**City of Portland, Maine - Building or Use Permit Application**

**Proposed Project Description:**  
Additions to Multi Family To Change from 2 to 3 Units with Garages Per Plans.

BUILDING PERMIT REPORT

DATE: 4/10/01 ADDRESS: 244 Veranda St CBL: 432-F-003001

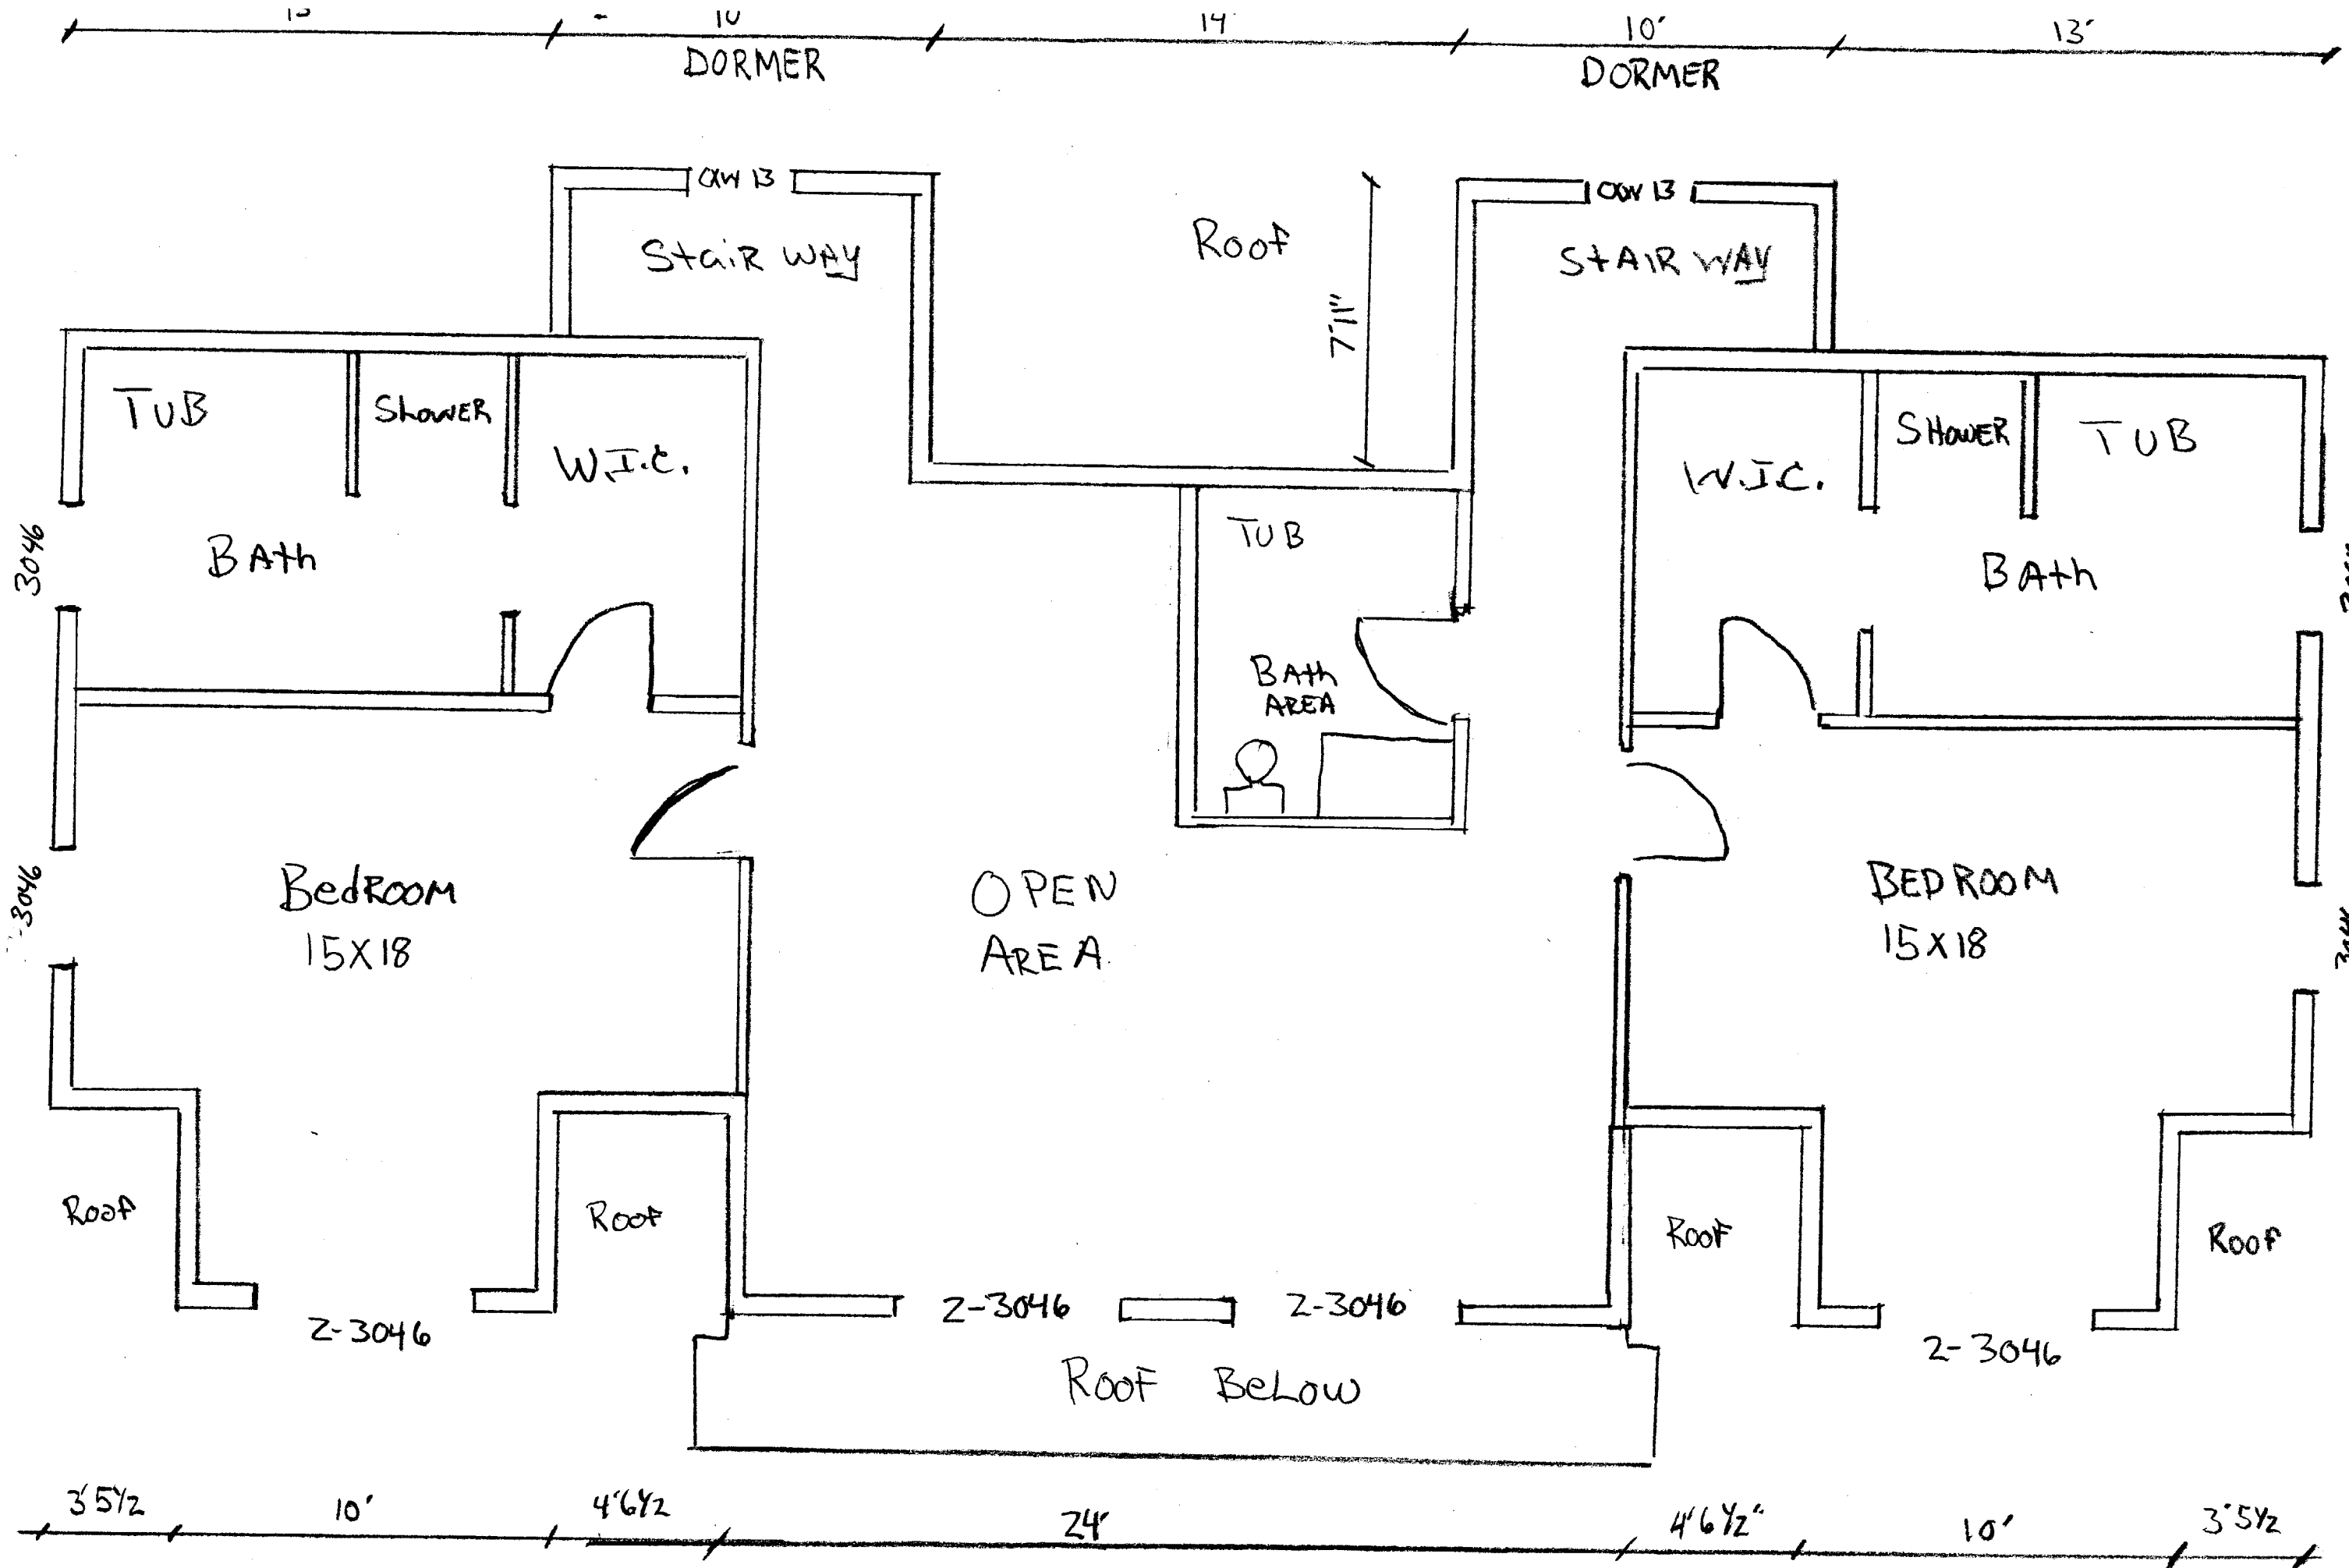
Front Yard - 20' req. or averaging ~~used~~ (Neighbors = 12+20' = 32' ÷ 2 = 16' req)  
 (50' can be allowed - 24' shown)  
 16' OK

Rear Yard - 20' req - 20' shown

Side Yard - 2 1/2 stories shown - 14' req - 9' & 20' shown - is allowed to reduce one side down to no less than 8' (9' shown) - 28 total needed, 29' shown

Third Floor PLAN  
1414.6 square feet.

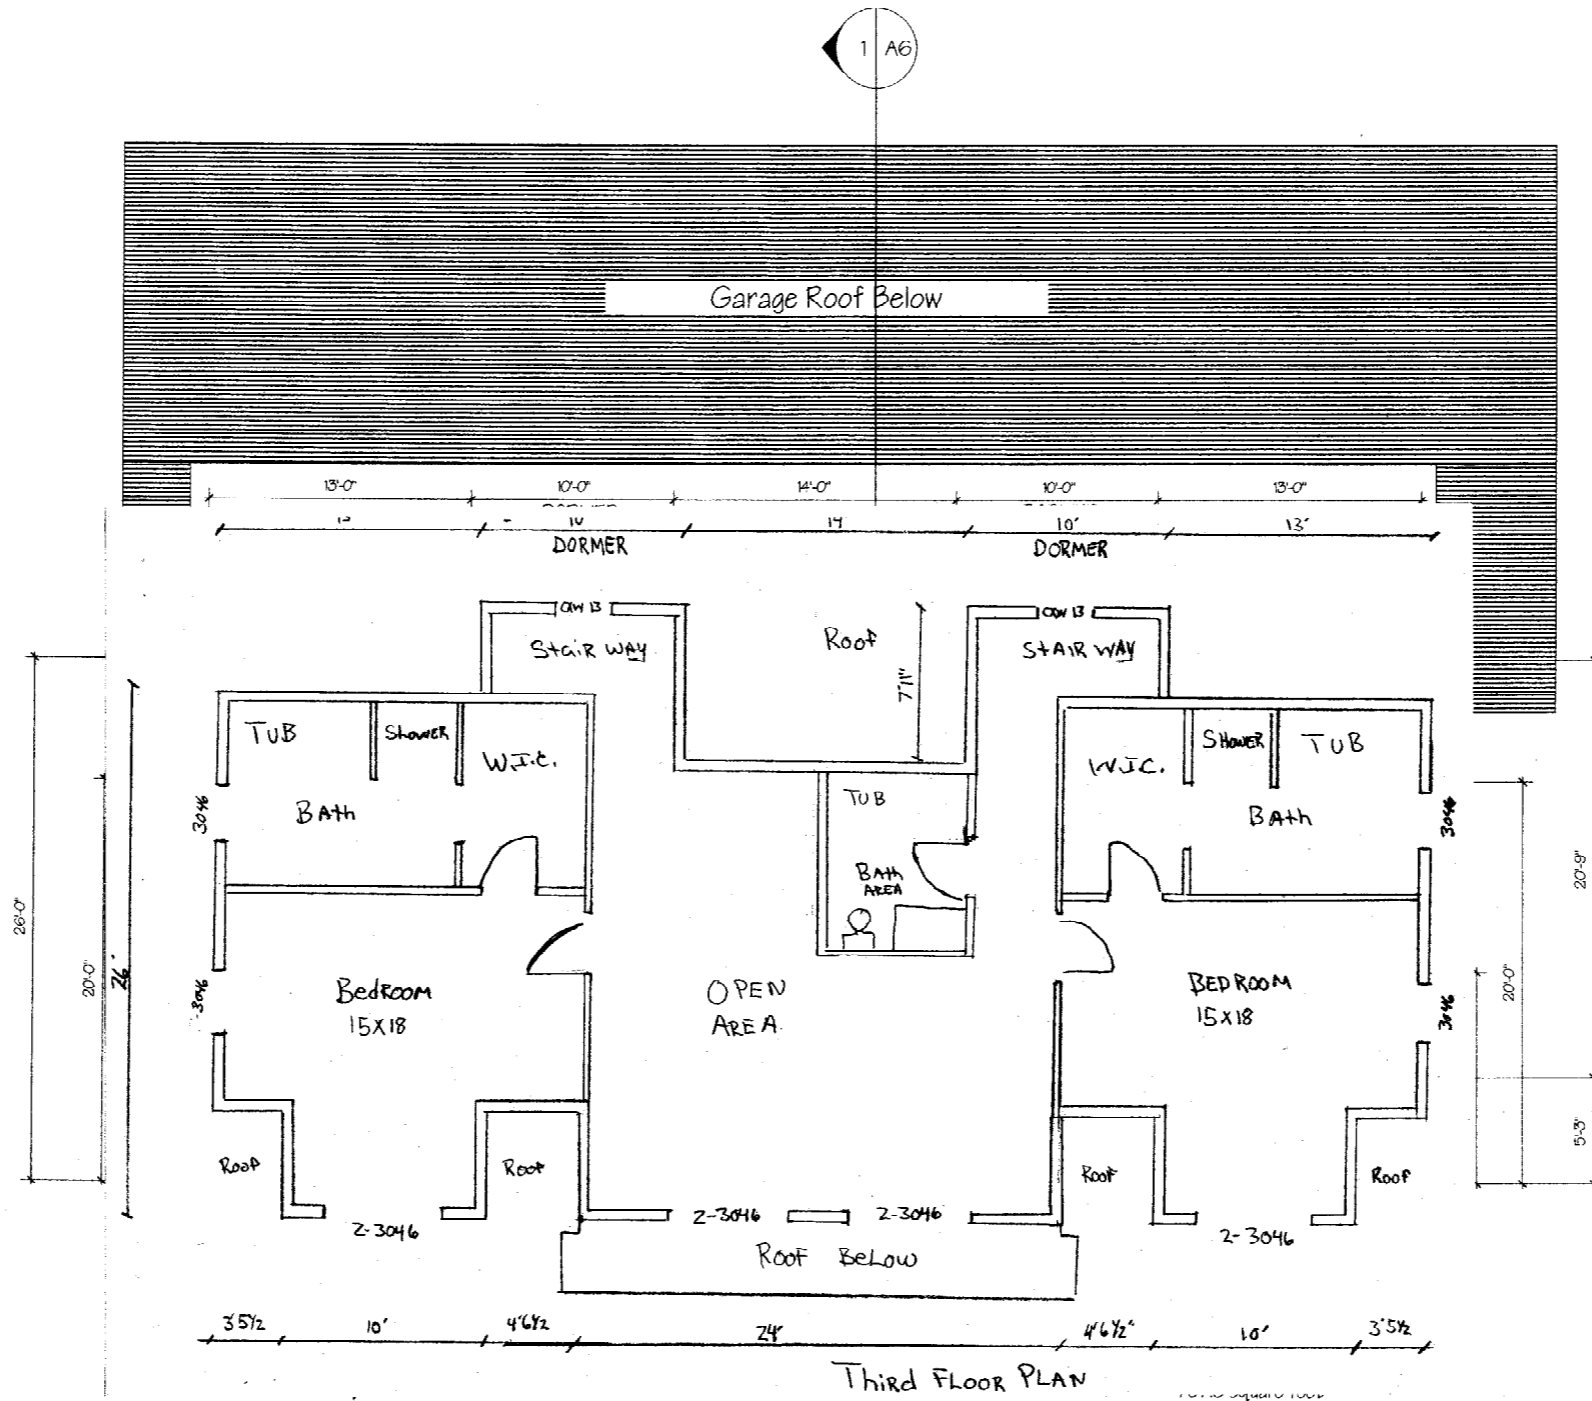
2nd floor =  $2172^{\#} \times \underset{\substack{\downarrow \\ 2/3}}{.66} = 1433.52^{\#}$

for 1/2 story status, this may not be more than  
 $\frac{2}{3}$  the square footage of the floor direct below.

3rd floor

$707.3^{\#} =$  upper floor of unit 2

$707.3^{\#} =$  upper floor of unit 3

$1414.60^{\#}$  total 3rd floor

can be considered  
 $2\frac{1}{2}$  stories for  
purposes of set back
